Boston Alternative Energy Facility

Report on Outstanding Deadline 2, 3 and 4 Submissions

Document Reference: 9.63

TITLE
**GENERAL LAYOUT DRAWING PLAN
FIGURE 5.1 - SHEET 1 OF 2**

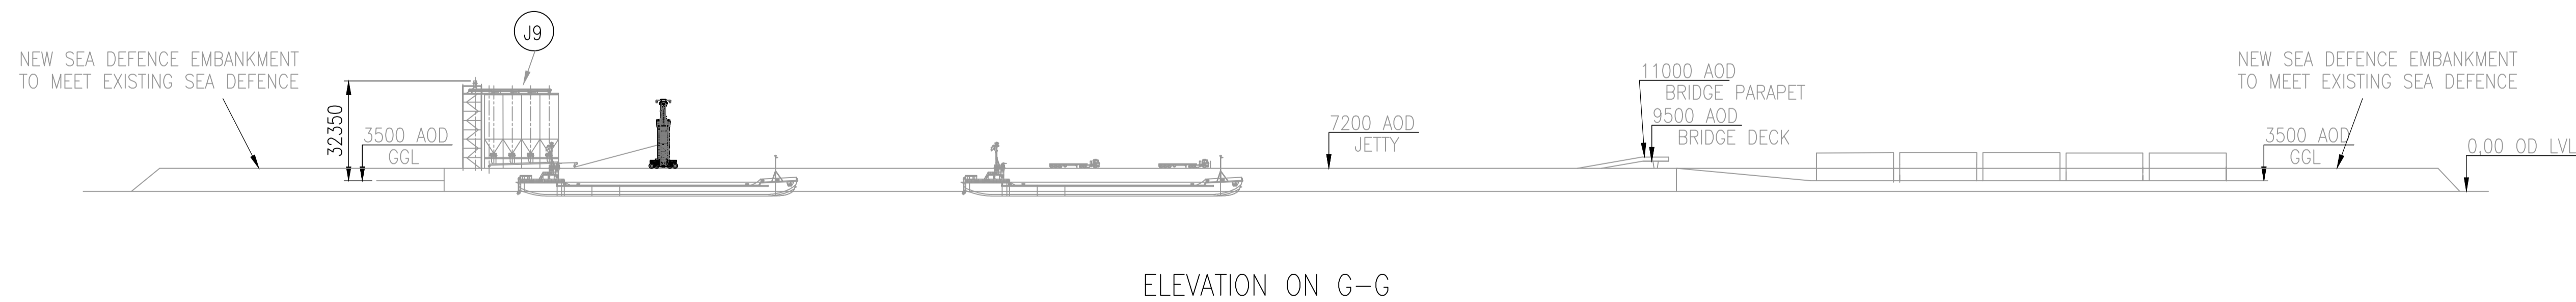
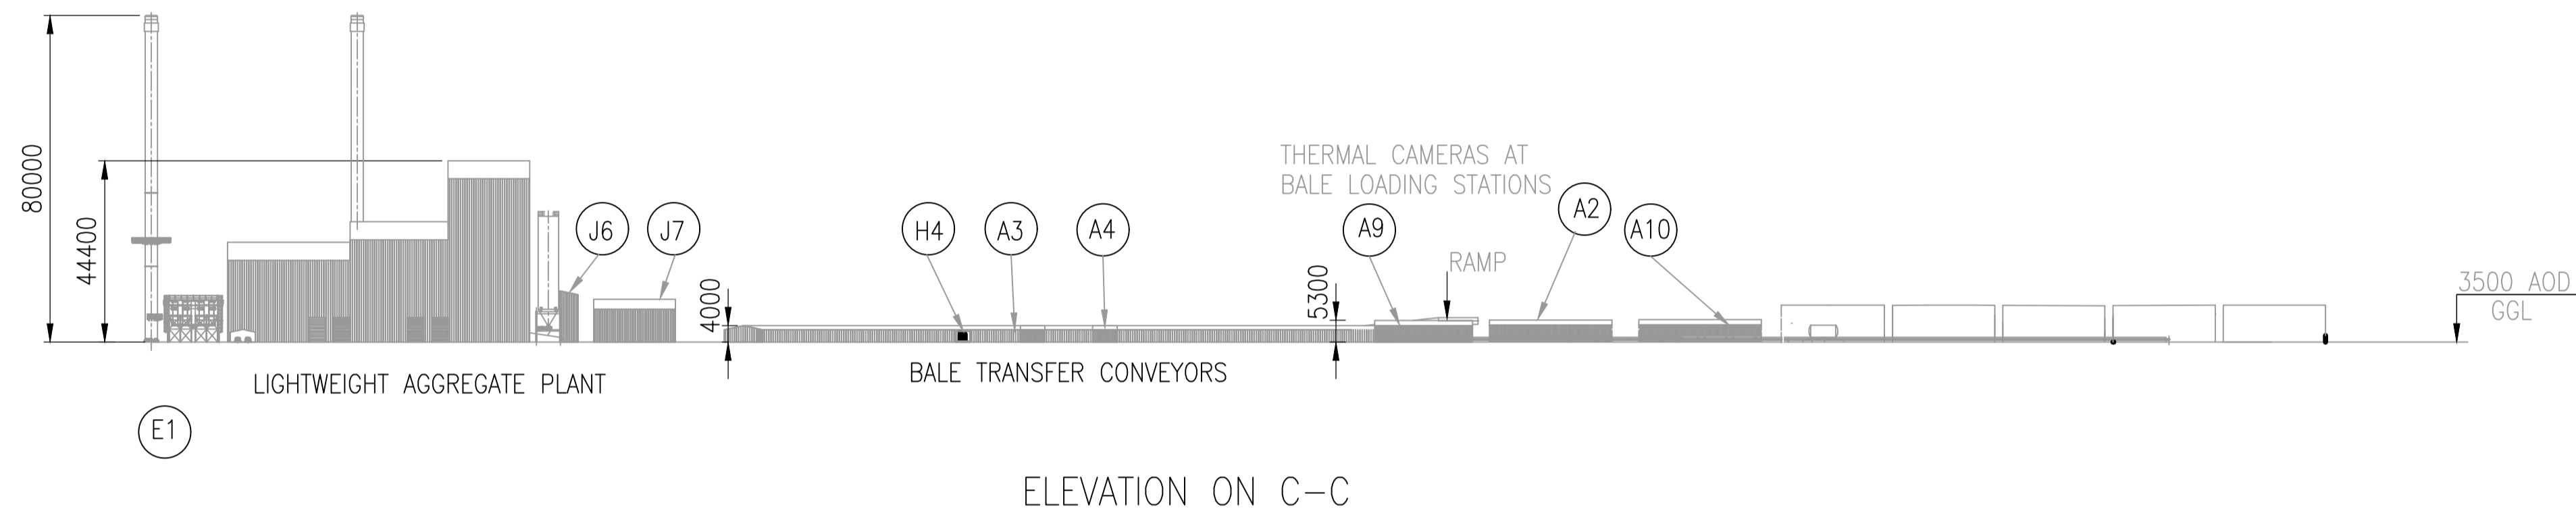
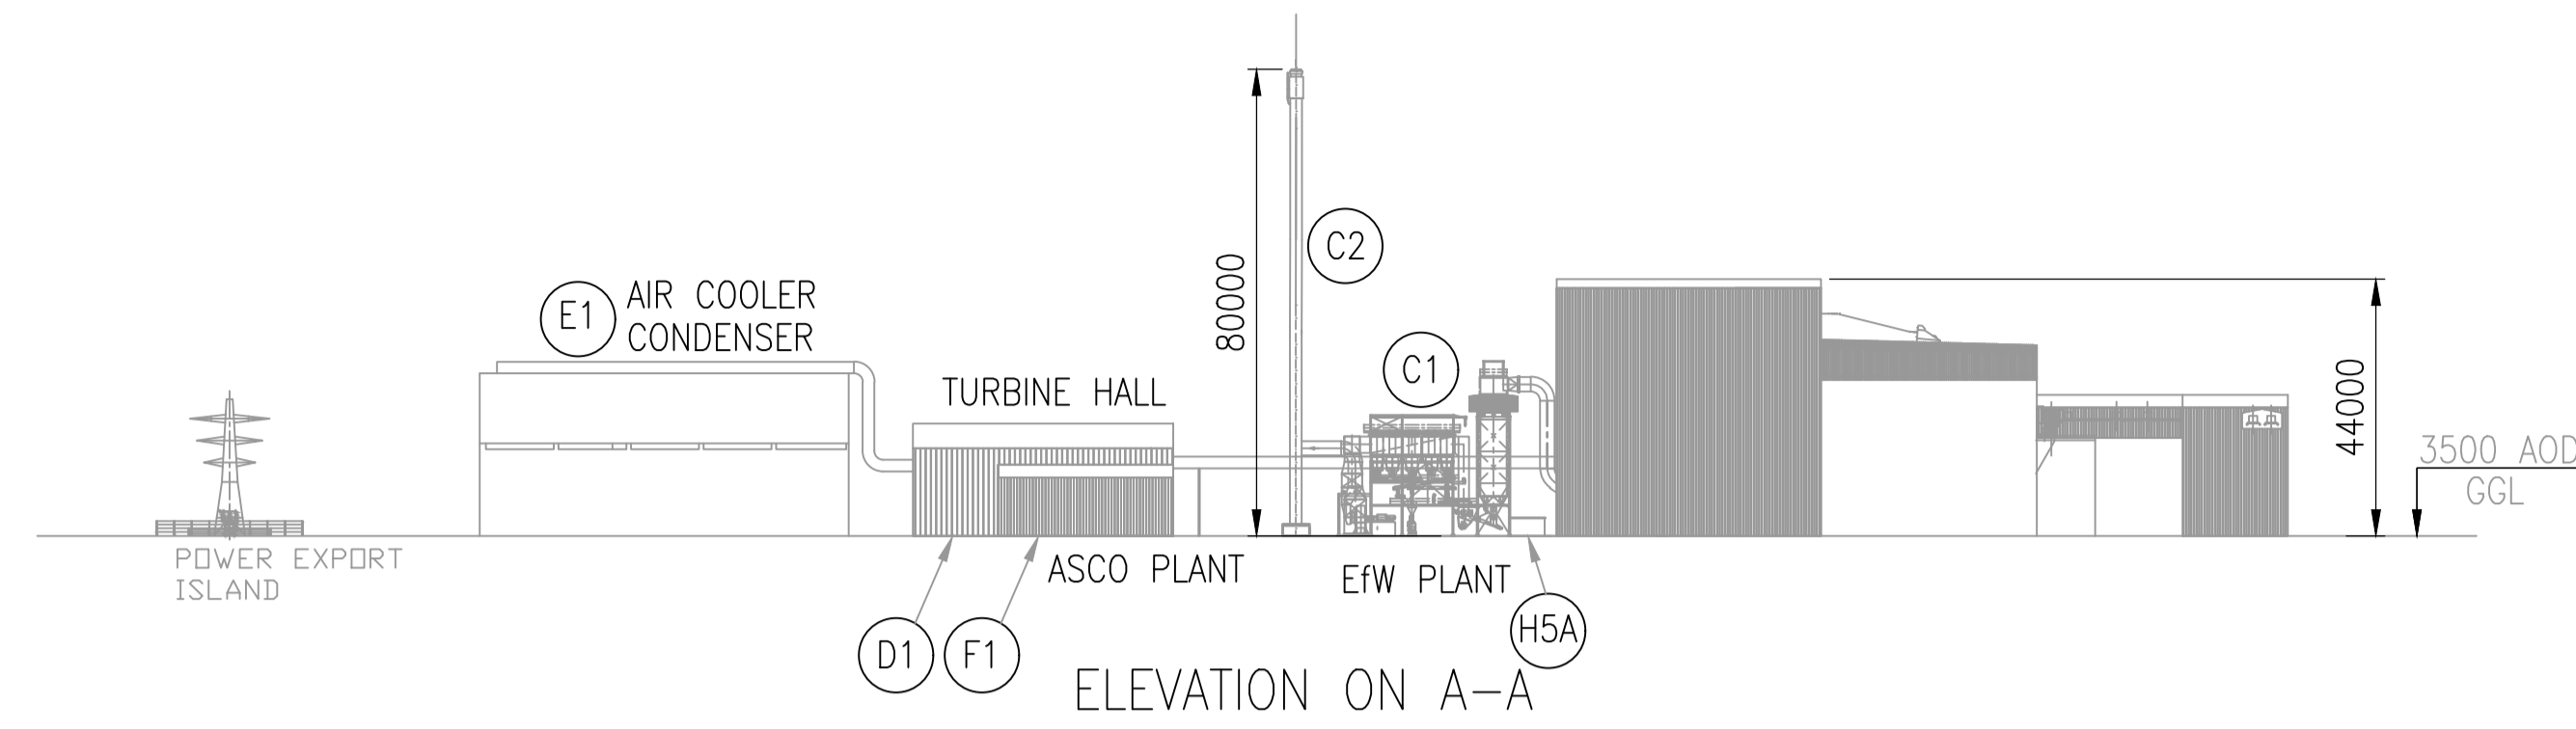
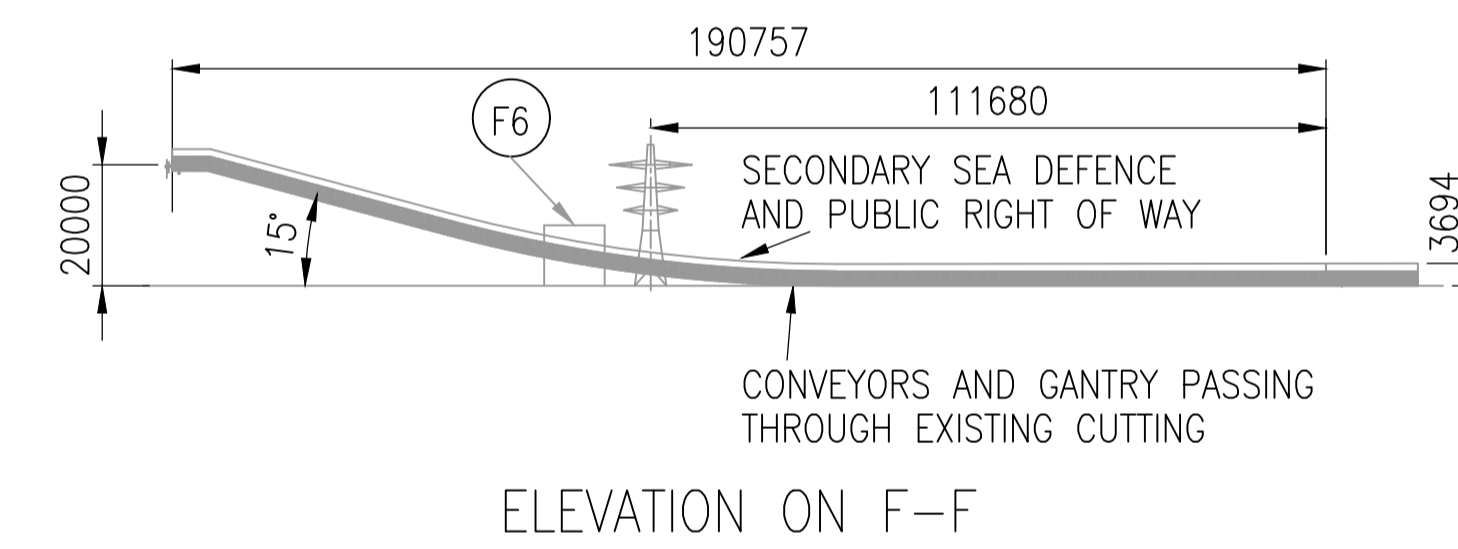
5	Natural England seeks further clarity from the Applicant on the overland conveyor location, and associated impacts, especially in relation to 89 shipments.	As described in Chapter 5 Project Description (document reference 6.2.5, APP-043), a concrete batching plant is being installed during construction to reduce transport movements associated with concrete. Aggregate will be brought in by ship

No.	Interested Party's Comment	The Applicant's Response
		and transferred by an overland temporary conveyor. The location of the temporary conveyor is shown and labelled on Figure 5.1 (sheet 1) (document reference 6.3.2, APP-068). As this is part of the Project Description, an assessment of its potential impacts has been included in relevant assessments including Chapter 17 Marine and Coastal Ecology (document reference 6.2.17, APP-055).
6	There remain issues in relation to direct/indirect loss of supporting intertidal habitat through scouring and dredging.	Section 6.3 of the Assessment of Alternative Solutions (document reference 9.28, REP2-011) covers the aspects of the Facility the Interested Parties consider have the potential for harm. This includes the construction and presence of the wharf and vessel transit through The Haven which covers associated activities such as dredging and scouring. The options for alternative solutions are focussed around these aspects, such as removing the need for a wharf (by using road or rail movements) which would remove the requirement for dredging and the need for vessels and therefore ship wash.
